MPC Ref: 160548

RE: Newcastle Jockey Club - Chatham Street Stables Complex (SSD-12982045)

MPC has prepared responses to the relevant items listed in the correspondence from the City of Newcastle ('CoN') reference SDC2021/0014 dated 10 June 2022.

TURNING PATH ENTRY PLAN SHEET 3

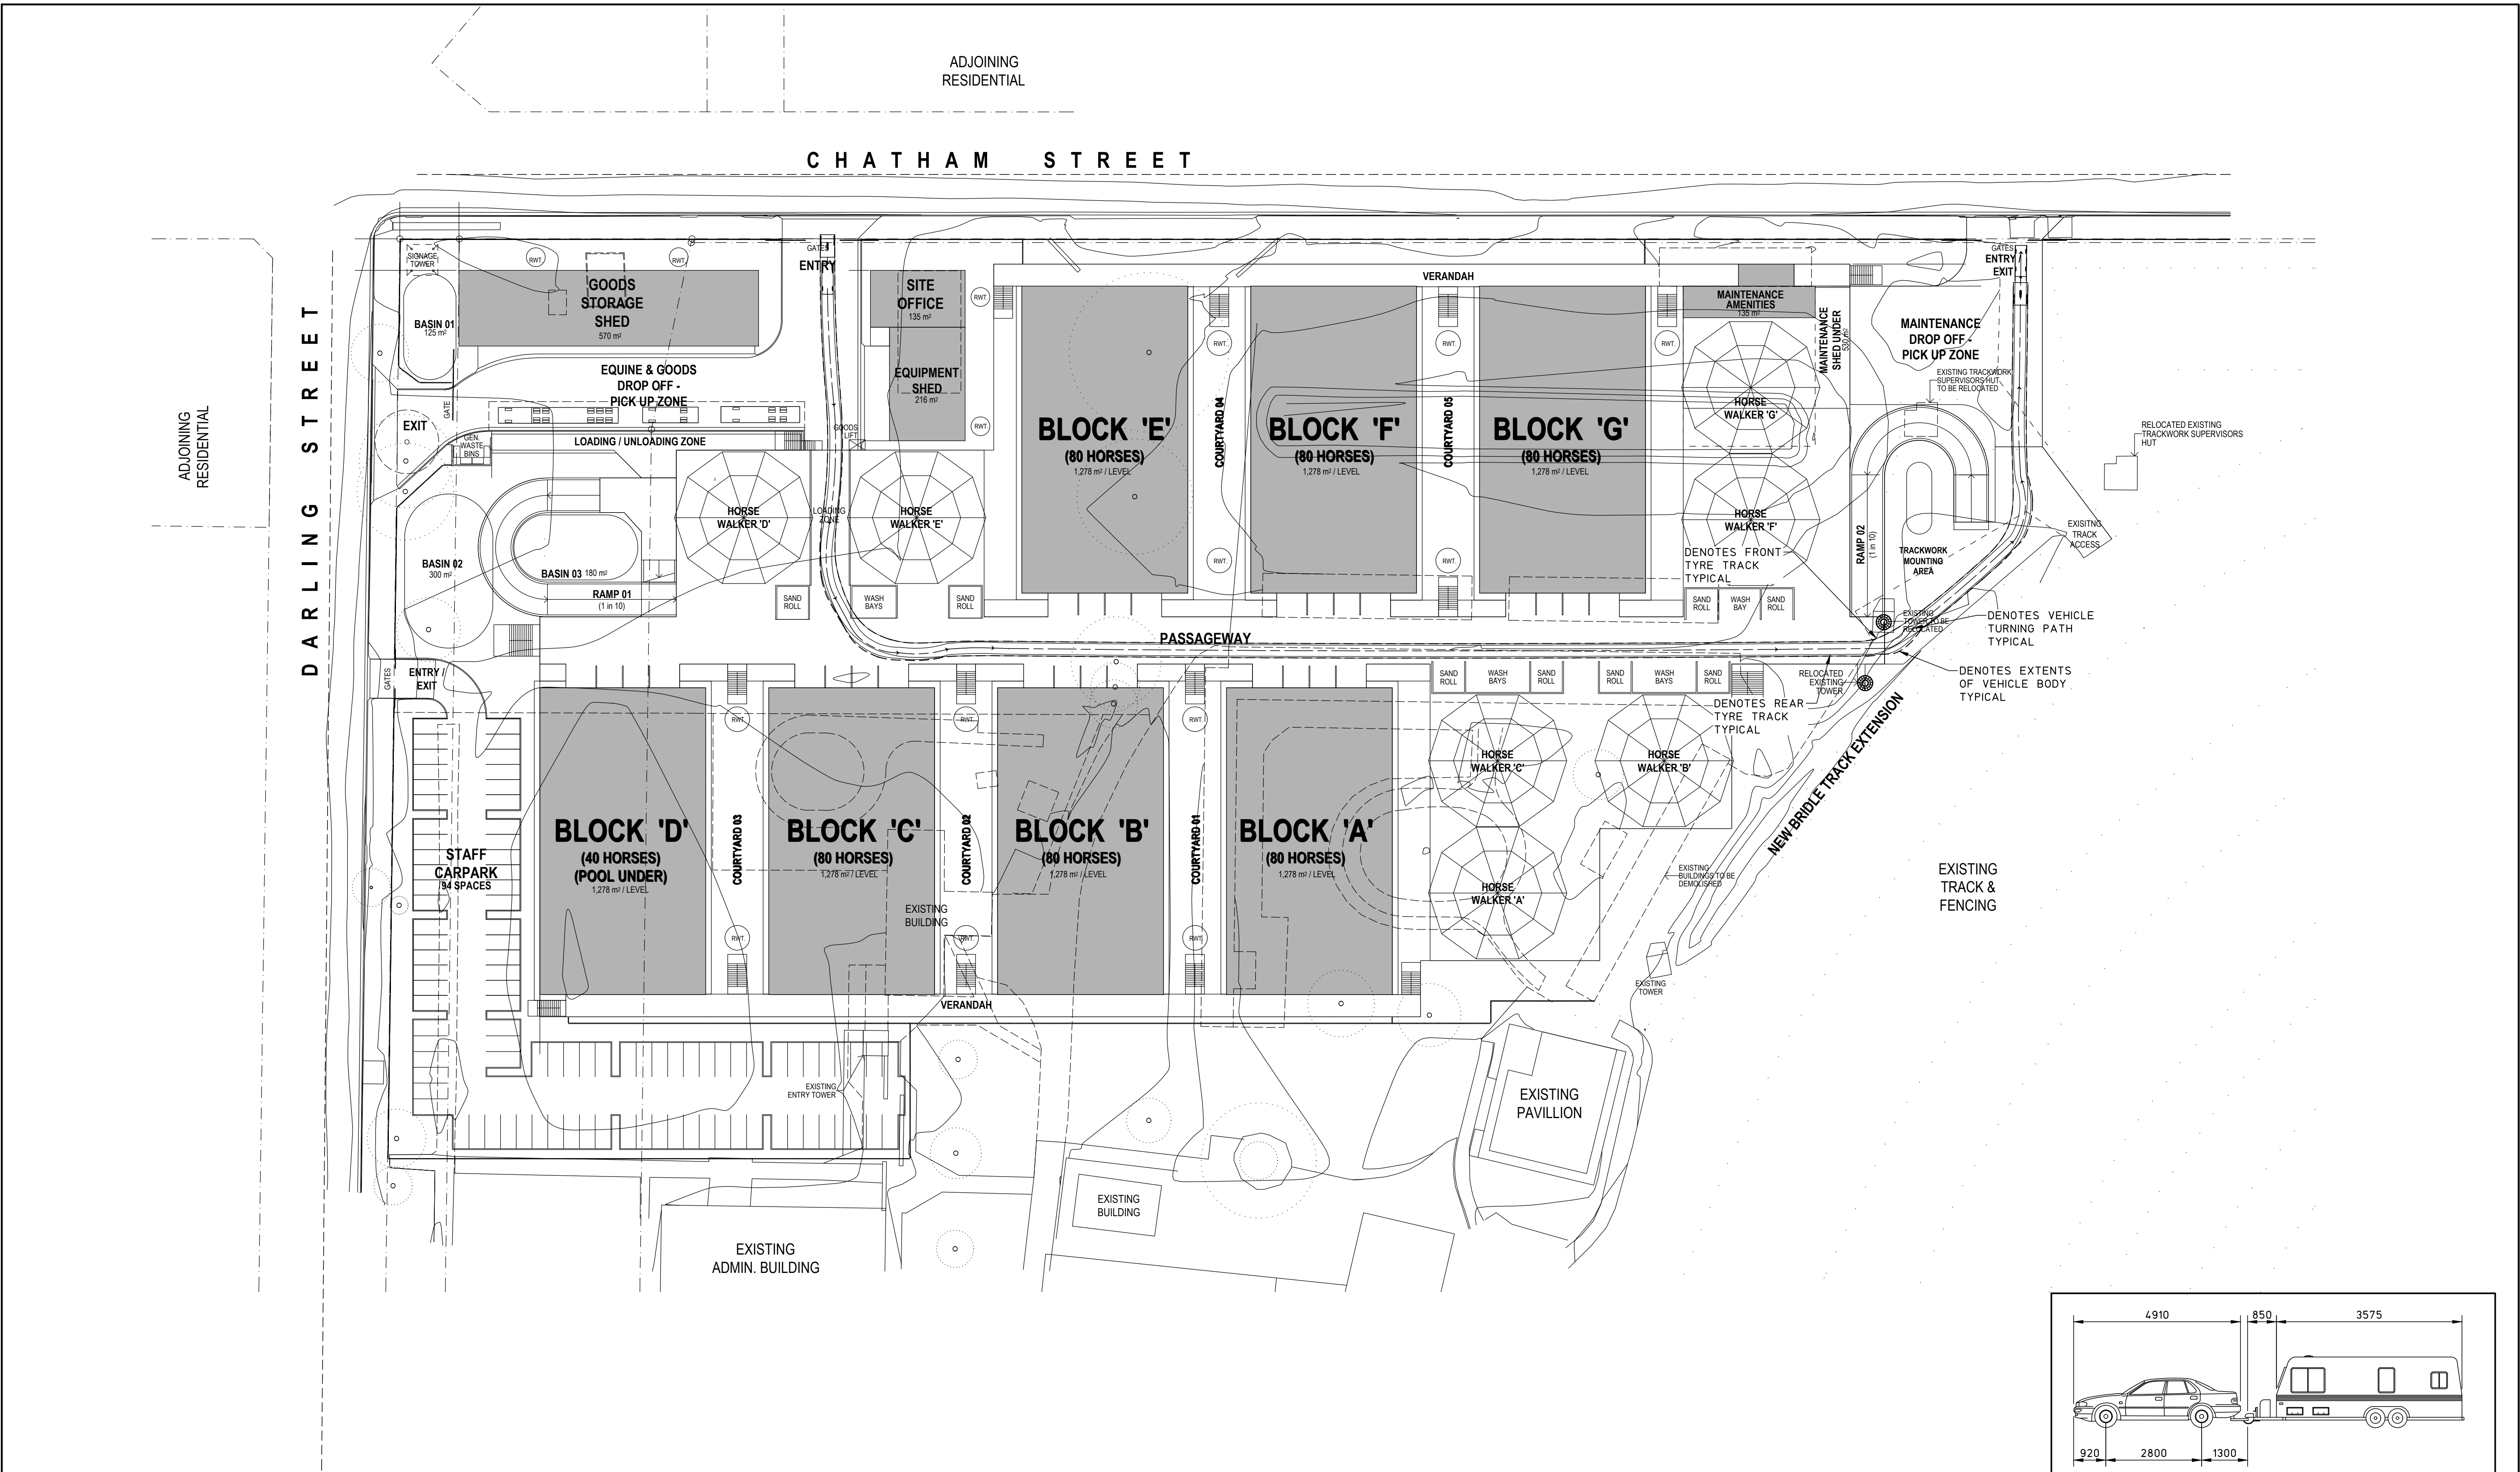
Furthermore, the turning path drawings indicate that the entry is very tight for manoeuvring. Use of larger B99 type vehicles is likely expected for such movements. Proposed gate and landscaping may have to be amended to allow for access for a B99+Horse Float to ensure the flexibility for manoeuvring.

Vehicle turning paths for emergency horse float access (on MPC Drawings T03, T04 and T05, Revision 4, dated 8 July 2022) have been updated to show a B99 vehicle with the horse float.

TURNING PATH ENTRY PLAN SHEET 4

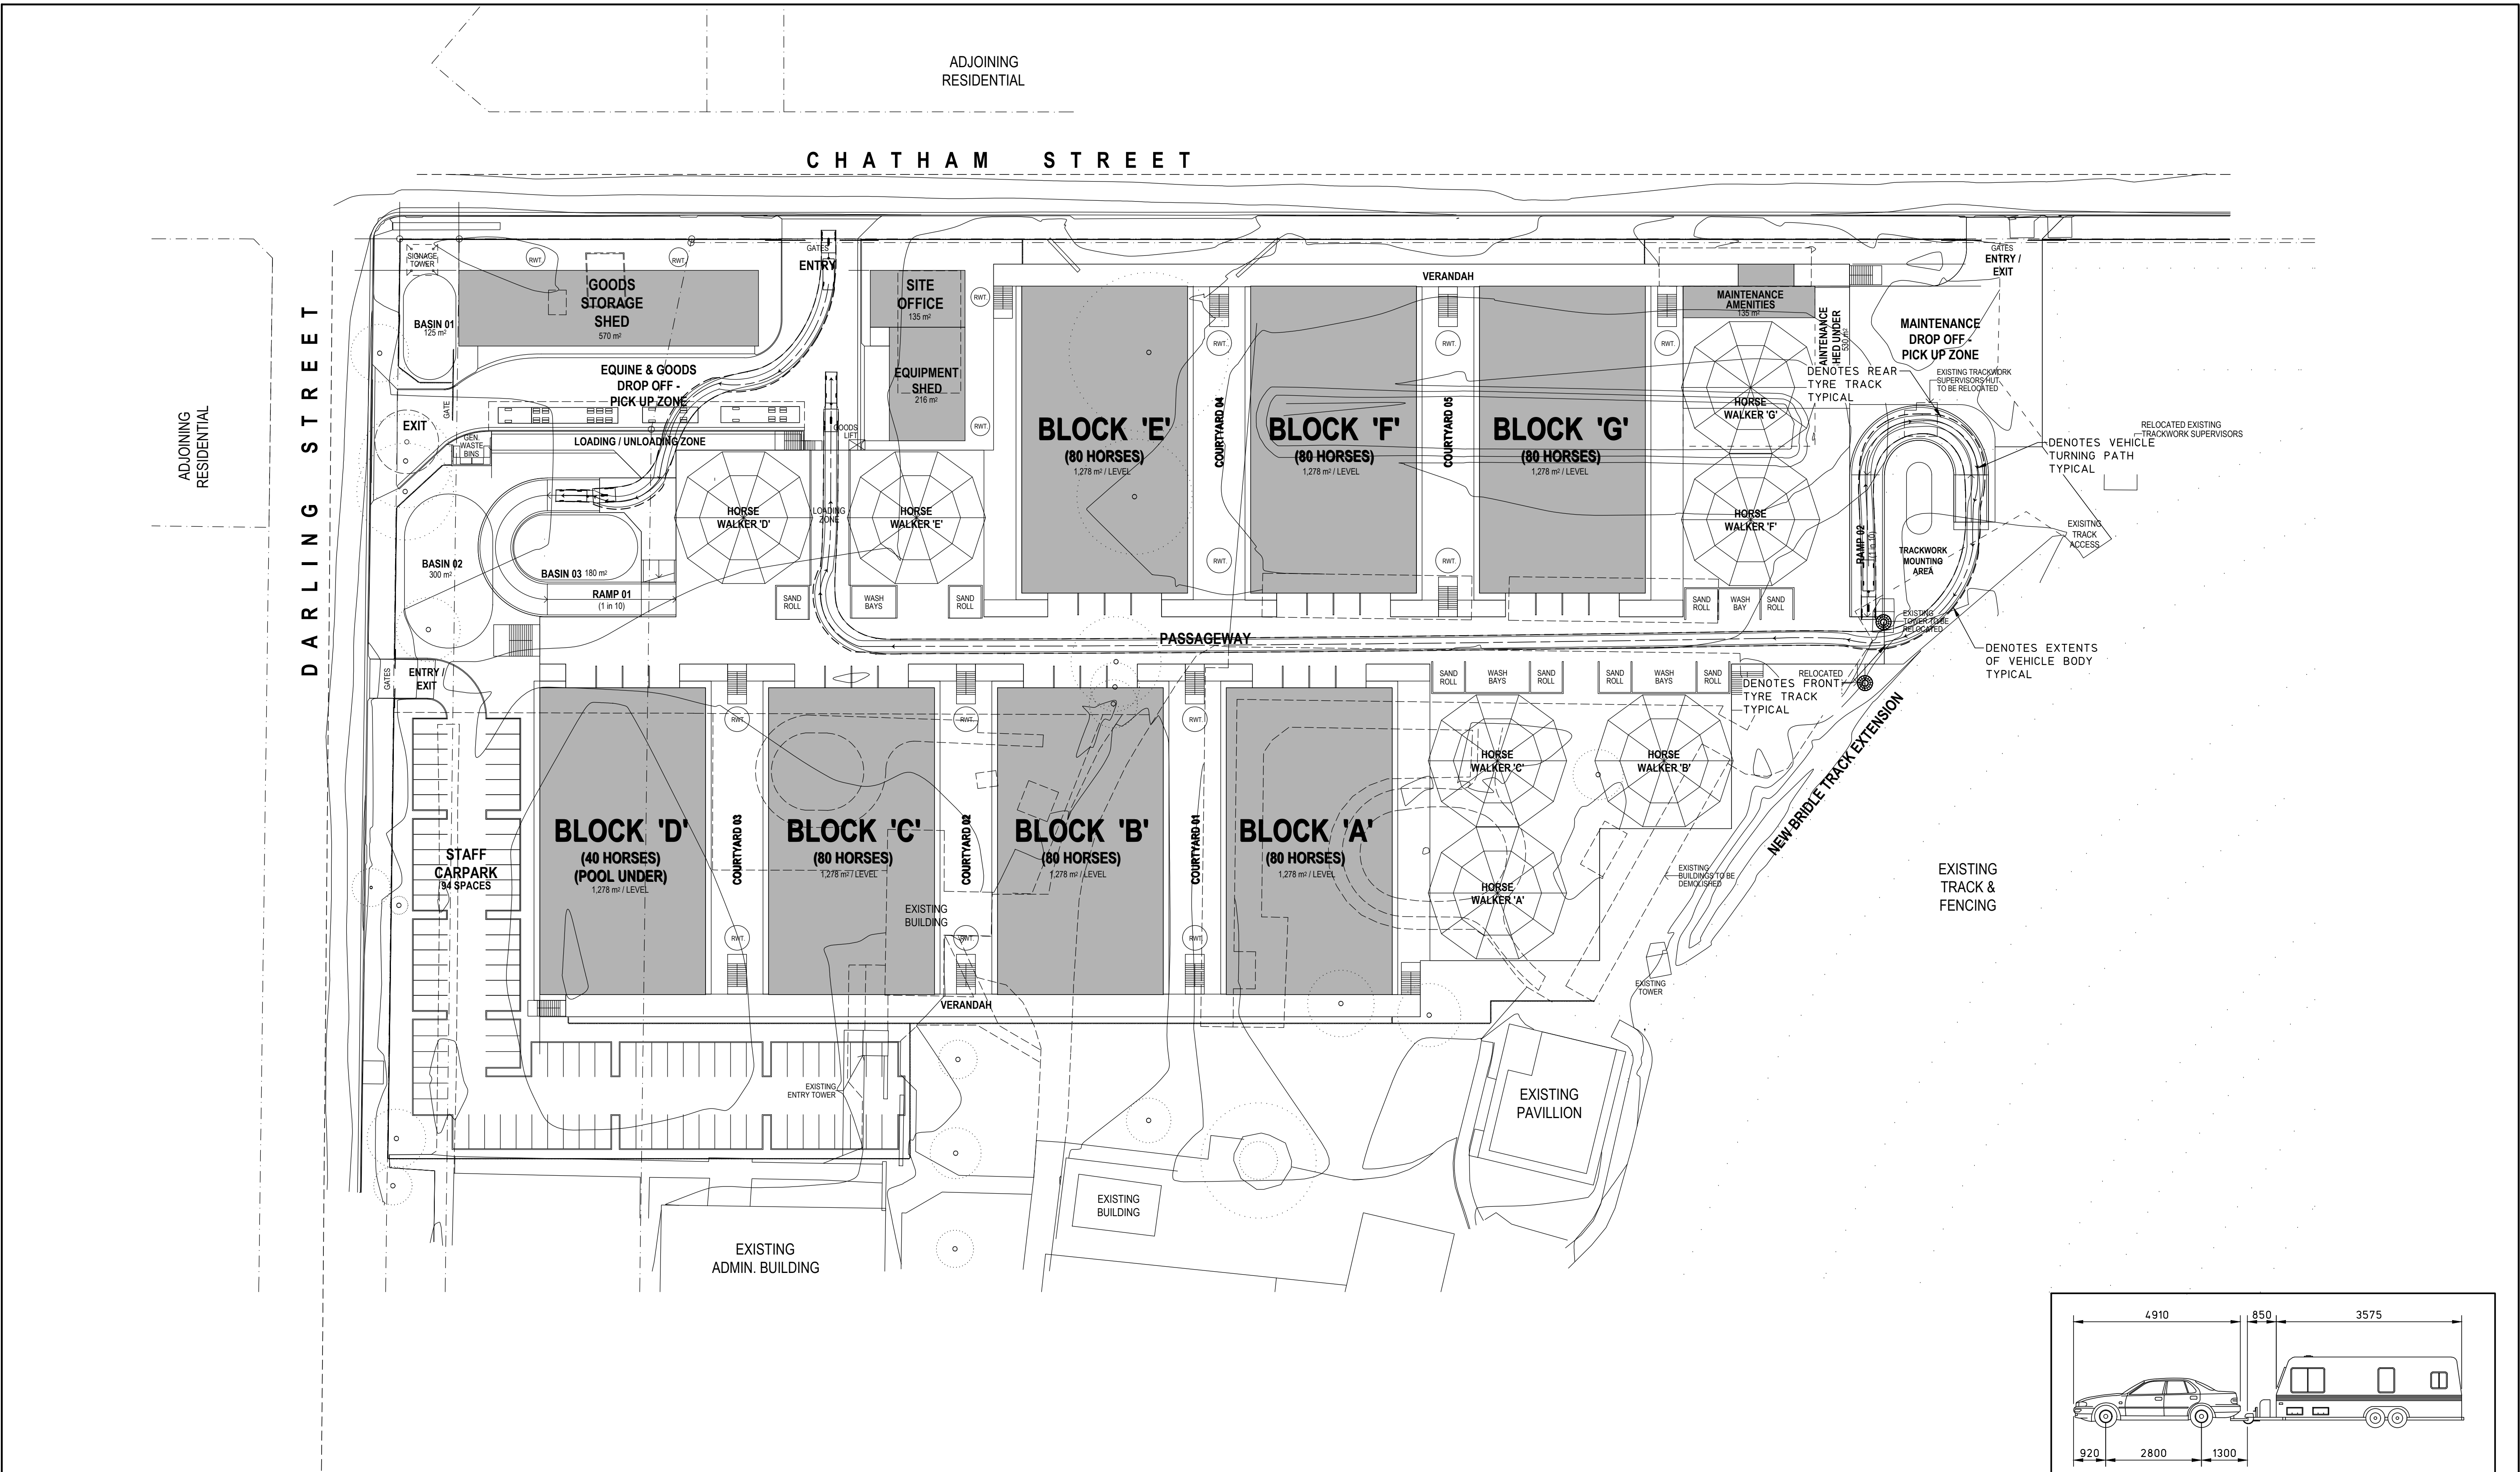
Turning Path Plan Sheet 4 (Dwg No. T04) indicates a B85+Horse Float will enter the site from the Equine/Goods Drop-off Entry driveway (south of Chatham Street) to the Ramp 01 via a gated control and exit at Ramp 02. A Loading Zone is proposed at the entry to Ramp 01 for the Equine/Goods Drop-off which will restrict entry to the Ramp 01. Concern is raised that the impact of this proposed entry to the Ramp 01 may adversely impact on the operation of the driveway and road traffic.

Turning Path Plan Sheet 4 (Dwg No. T04) indicates a B85+Horse Float will drive via the Lower Passage and use the Equine/Goods Drop-off Entry driveway (South of Chatham St) to exit onto the road. Safety concern is raised regarding the above turning pattern as it could result in a head on collision.

The ramps were checked for vehicle access to ensure there is emergency access for a vehicle and float to pick up an injured horse from a stable. The frequency of such access would be very rare and not part of the regular day-to-day operation of the facility. Traffic controls would be implemented by NJC personnel in the rare event that float access to the stables was needed to retrieve an injured horse. We therefore do not foresee a problem with the ramp position or geometry as currently proposed in the design.

The ramps were checked for vehicle access to ensure there is emergency access for a vehicle and float to pick up an injured horse from a stable. The frequency of such access would be very rare and not part of the regular day-to-day operation of the facility. Traffic controls would be implemented by NJC personnel in the rare event that float access to the stables was needed to retrieve an injured horse. The very low risk of collisions can therefore be safely managed by the above-mentioned traffic controls in the rare emergency event that access by the float was required.
